RE: Harnett County Land Use Application #08-5-20991R

Based on the criteria set out in Title 15A, Subchapter 18A, of the North Carolina Administrative Code, Rules .1950, the evaluation indicated that the site is **UNSUITABLE** for the addition requested. Therefore, your request for a revision is **DENIED**. The site is denied based on the following:

Harnett County Department of Public Health Site Sketch

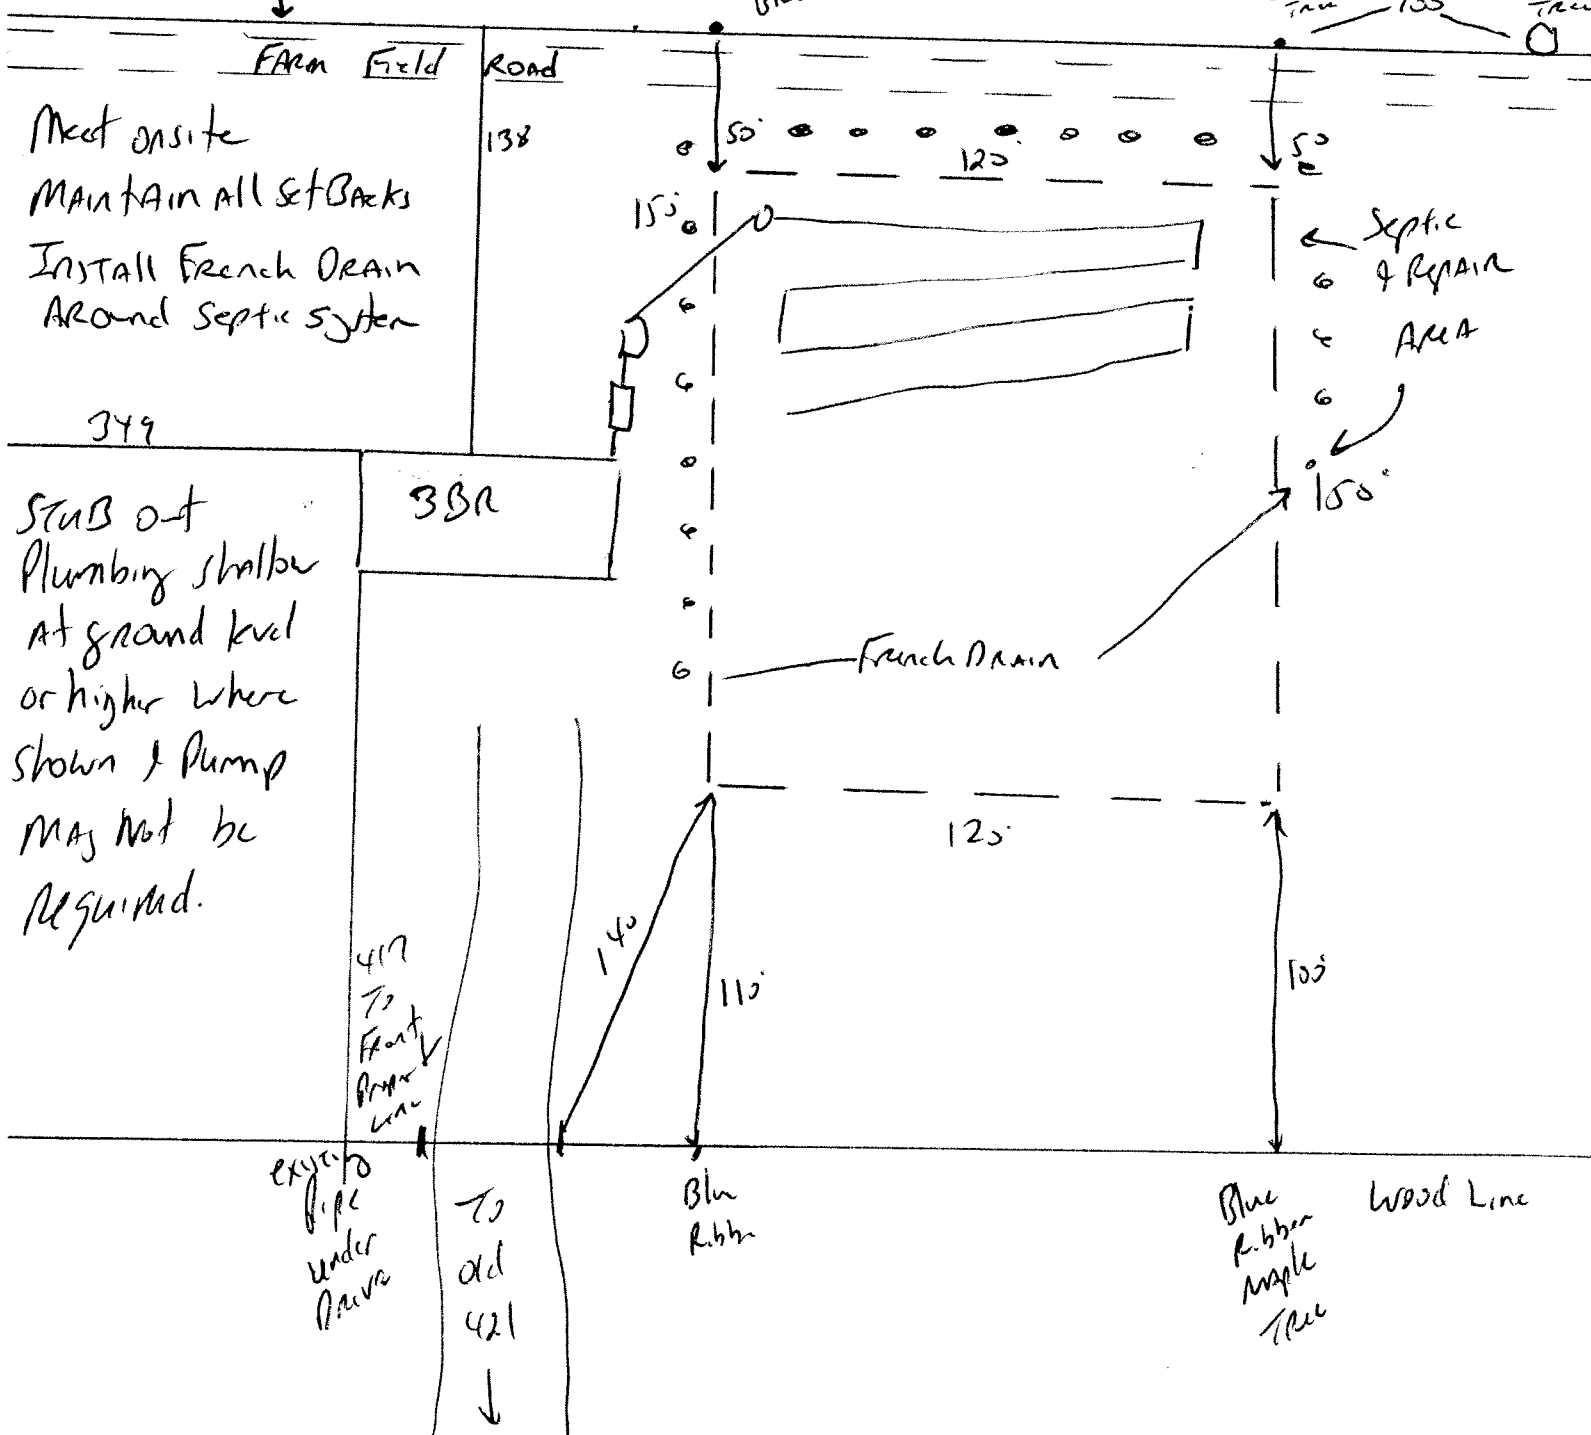
X 15A NCAC 18.1945 (b) Each lot shall have original septic system plus repair area.

X 15A NCAC 18A.1950 (10) – Any building to be 5' from drain line.

The barn is in the middle of proposed septic area (see attached permit). The area is marked by the blue flags placed on site. You have the option to move the barn out of the septic and repair area.
